M5 Junction 10 Improvements Scheme

Applicant's Responses on Deadline 2 Submissions

TR010063 - APP 9.44

Applicant's Responses on Deadline 2 submissions

# M5 Junction 10 and Surrounding Active Travel Networks - Plan 2

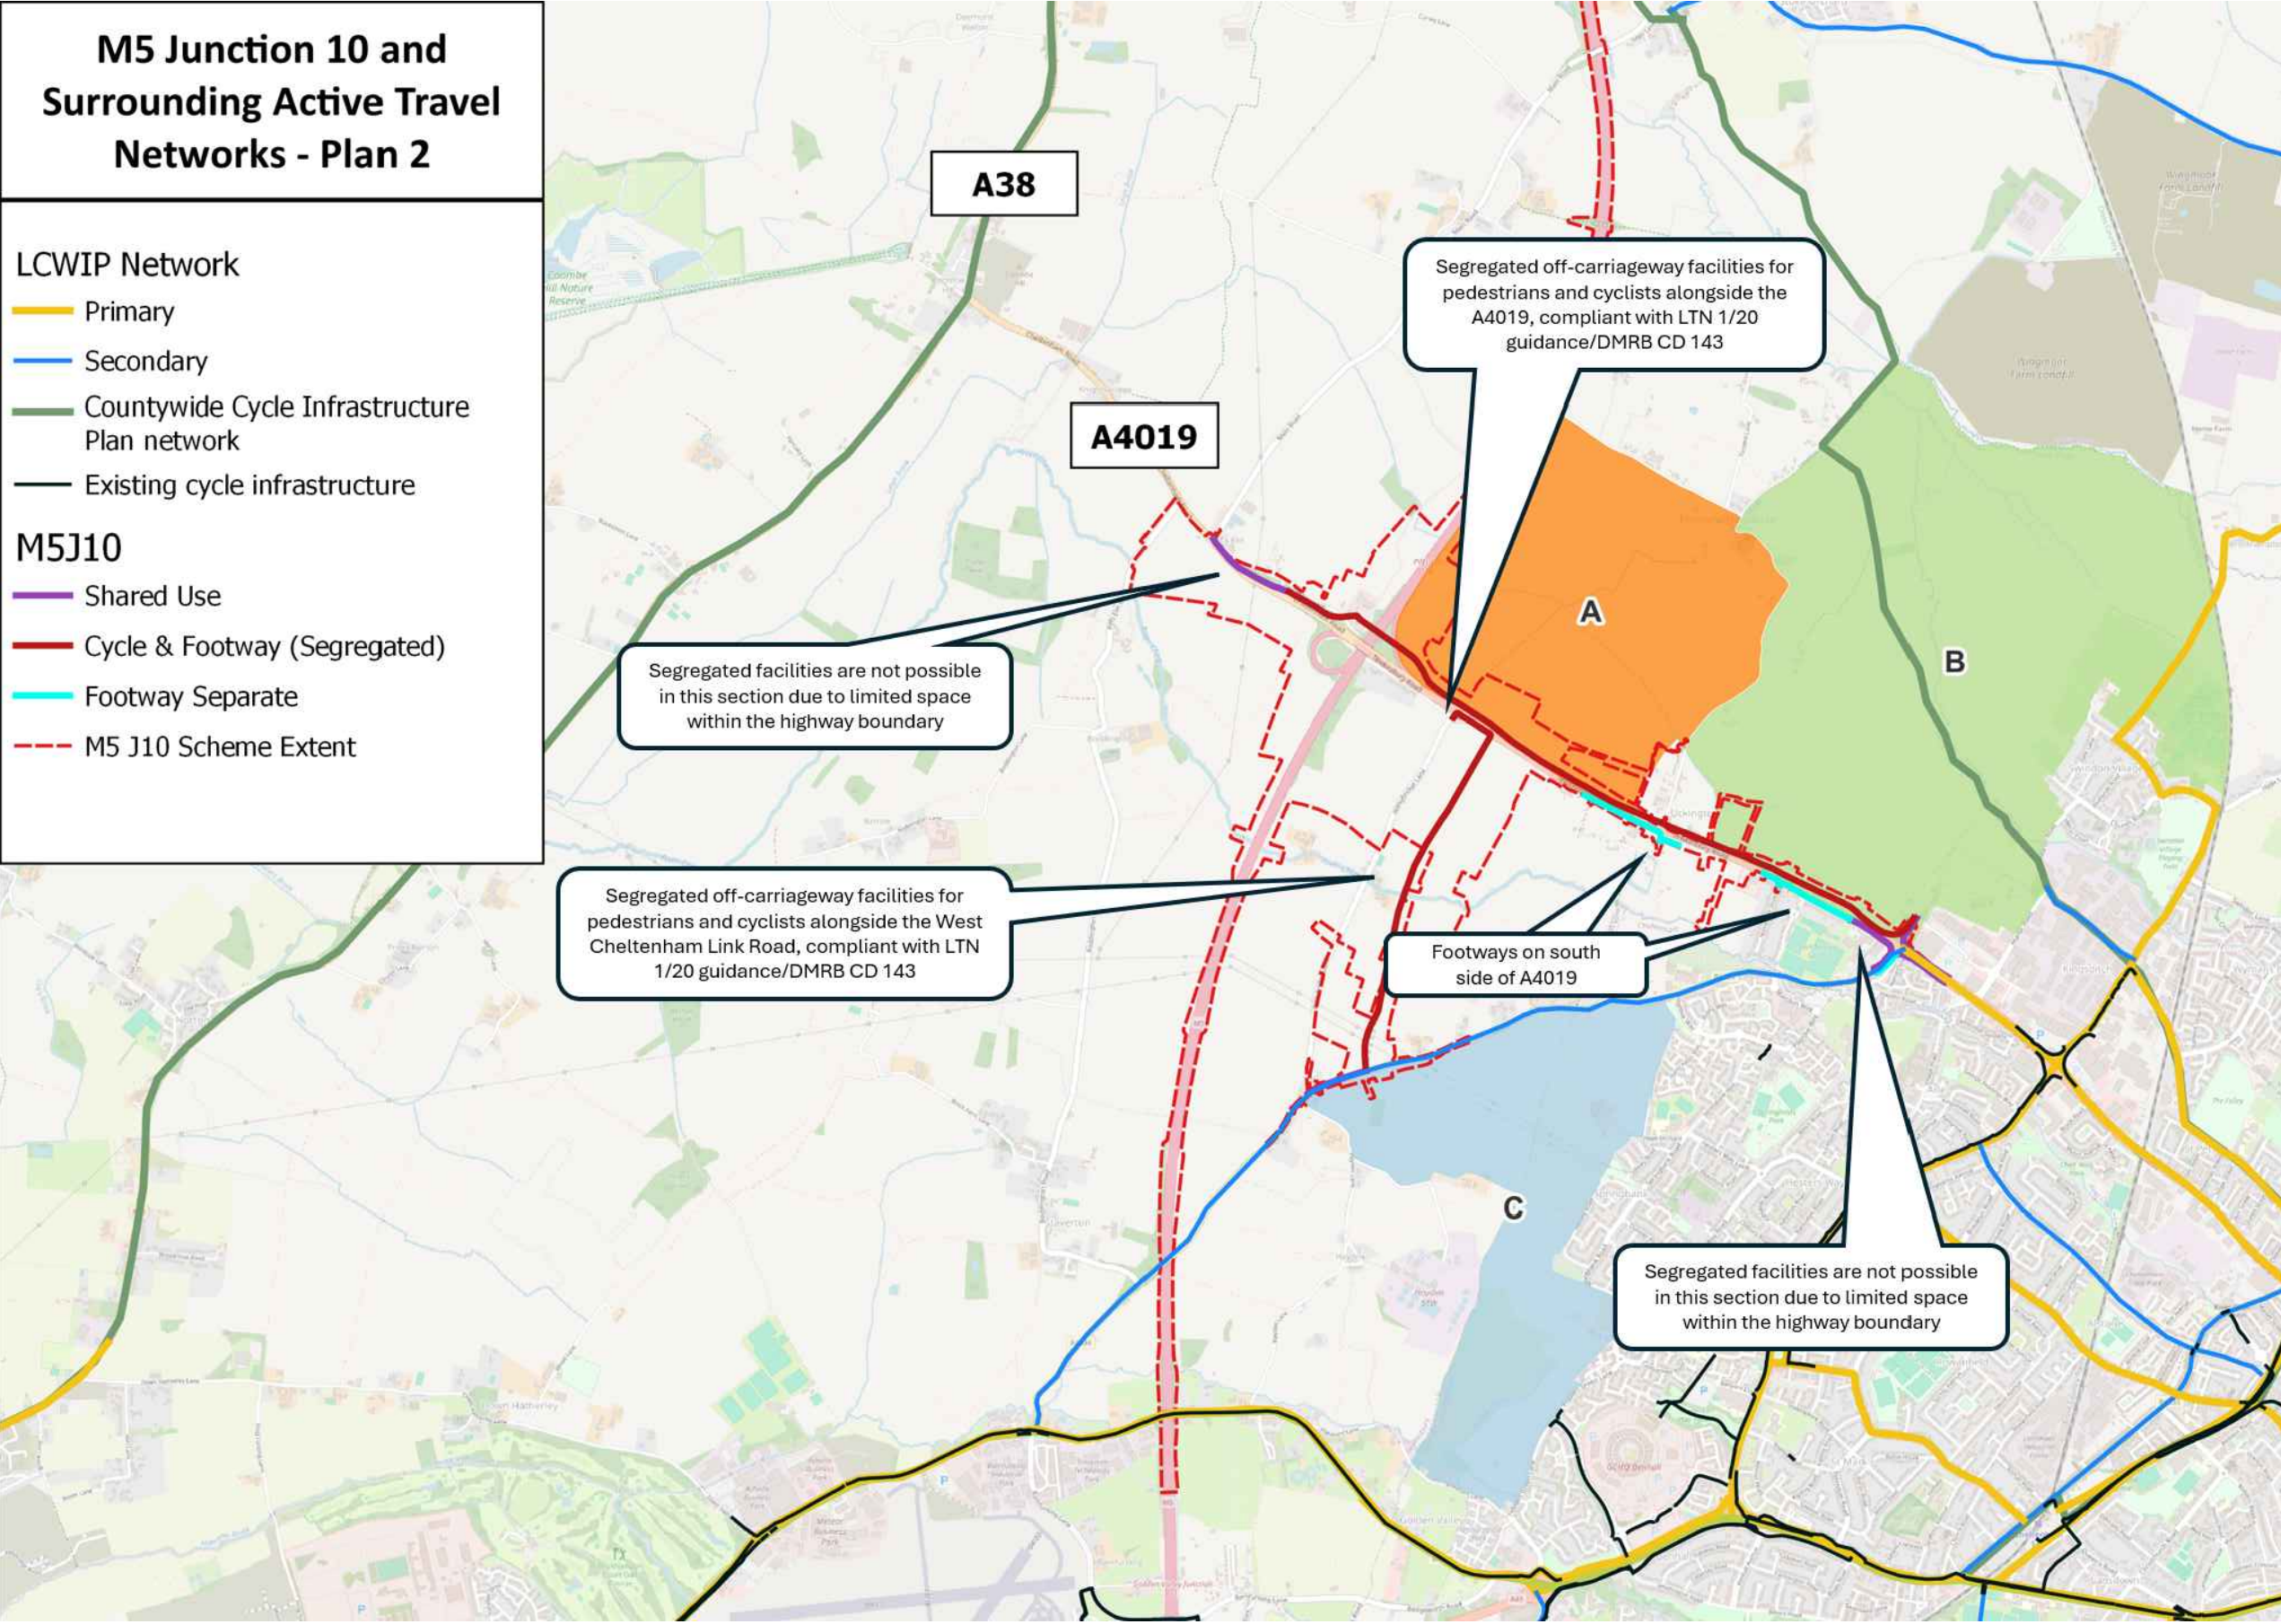
Response Reference	Relevant Representation Issue	Applicants Response
39.22 to 39.27	<p>Transport Assessment, Highways and Design</p> <p>Joint Council response at D2:</p> <p>The Joint Councils would like to see some high-level plans setting out the cycle network with the opportunities listed within the WCHAR report identified.</p> <p>It is noted that good pedestrian and cycle infrastructure provision is included in the extents of the Scheme itself, ideally additional buffers should be provided as highlighted in the detailed comments provided. It would be useful to have a clear strategic cycle network plan presented.</p> <p>The Central Severn Vale Cycling and Walking Infrastructure Plan (CSV LCWIP) and the principles of the Connecting Cheltenham report (2019) should be considered, to clearly demonstrate where the missing links are and how the Scheme will support the delivery of improved connectivity for sustainable modes.</p> <p>A clear plan setting out the sustainable transport provision for all modes adjacent and through the Scheme would be beneficial e.g., bus, cycle and pedestrian.</p> <p>The Joint Councils would like a summary plan of the movements and how all modes will be provided to/through the local development sites.</p> <p>There are missing links and therefore these need to be clearly identified with an understanding of future opportunities around delivery of these for example, west towards A38 Coombe Hill along the A4019.</p> <p>The Tewkesbury Rd corridor becomes more urban focussed as you approach Cheltenham centre and therefore, the design approach needs to reflect this in the approach to pedestrian and cycle infrastructure. Rather than capacity improvements continuing to be prioritised, pedestrian and cycle provision needs to be the design focus.</p>	<p>The Applicant considers the WCHAR (APP-139) to provide all the required information on current provision for walking, cycling and horse-riding in the vicinity of the Scheme and sets out the opportunities for improvement. The design of the Scheme incorporates the walking, cycling and horse-riding improvements recommended in the WCHAR that are within the scope and extent of the Scheme.</p> <p>In addition, plans showing the strategic cycle network are publicly available elsewhere.</p> <p>The Applicant does not therefore consider it necessary to produce high-level plans setting out the cycle network with the opportunities listed within the WCHAR.</p> <p>The segregate pedestrian and cycle facilities included in the Scheme have been designed with appropriate buffer strips segregating them from carriageways in accordance with good practice guidance, specifically LTN1/20 - Cycle infrastructure design. Therefore, the Applicant does not consider that the “additional buffers” are necessary for the Scheme.</p> <p>Regarding the request for a summary plan of the movements and how all modes will be provided to/through the local development sites. The Applicant considers that it is not for the Scheme to determine how all modes will be provided to/through the local development sites. This is a matter between the each of the promoters of developments on the JCS sites and both the Local Planning Authority and Highway Authority when planning applications are submitted for determination based on the site-specific Transport Assessments and Travel Plans supporting each application.</p> <p>The missing links referred to, including west towards Coombe Hill along the A4019 connecting with the A38, are all outside the scope of the Scheme.</p> <p>The developers of the JCS allocated and safeguarded sites will be required to implement, or finance through s106 contributions, appropriate</p>

Response Reference	Relevant Representation Issue	Applicants Response
	<p>To the west, between Coombe Hill and J10, the cycle provision is shared use and does not connect with the existing cycle infrastructure connecting Tewkesbury along the A38.</p> <p>The Joint Councils would like to understand how this could be addressed in the Scheme design. Sustainable modes should be considered up front in providing a complete network linked to the identified development sites to the west of Cheltenham.</p> <p>It is recommended the information within the Transport Assessment and WCHAR reports is summarised taking account of the detailed comments provided separately. Understanding the relationship of the future year scenarios and the development phasing will help to support sustainable transport provision.</p>	<p>and proportionate improvements for public transport, walking and cycling that will complement the provision for these modes incorporated into the Scheme. This will be based on the Transport Assessments and Travel Plans submitted in support of individual planning applications.</p> <p>The Scheme design has considered sustainable modes upfront and incorporates improvements for pedestrians, cyclists and horse-riders as recommended in the WCHAR, as well as facilitating improved public transport provision, with the inclusion of a bus lane along the A4019.</p> <p>It is not the purpose of the Scheme to deliver all the public transport, walking and cycling infrastructure necessary to make the individual developments on the JCS allocated and safeguarded sites acceptable in planning terms. However, the Scheme allows for and facilitates the future introduction of sustainable transport measures associated with individual planning applications.</p> <p>For the aforementioned reasons, the Applicant does not consider it necessary to provide further information within an updated Transport Assessment on provision for sustainable modes.</p> <p>The Applicant is continuing to engage with the Joint Councils to resolve outstanding matters, with progress being reflected in an update to the SoCG which will be submitted to the Examination. The Applicant hopes to be able to provide this at Deadline 4, depending on the progress of this document.</p>
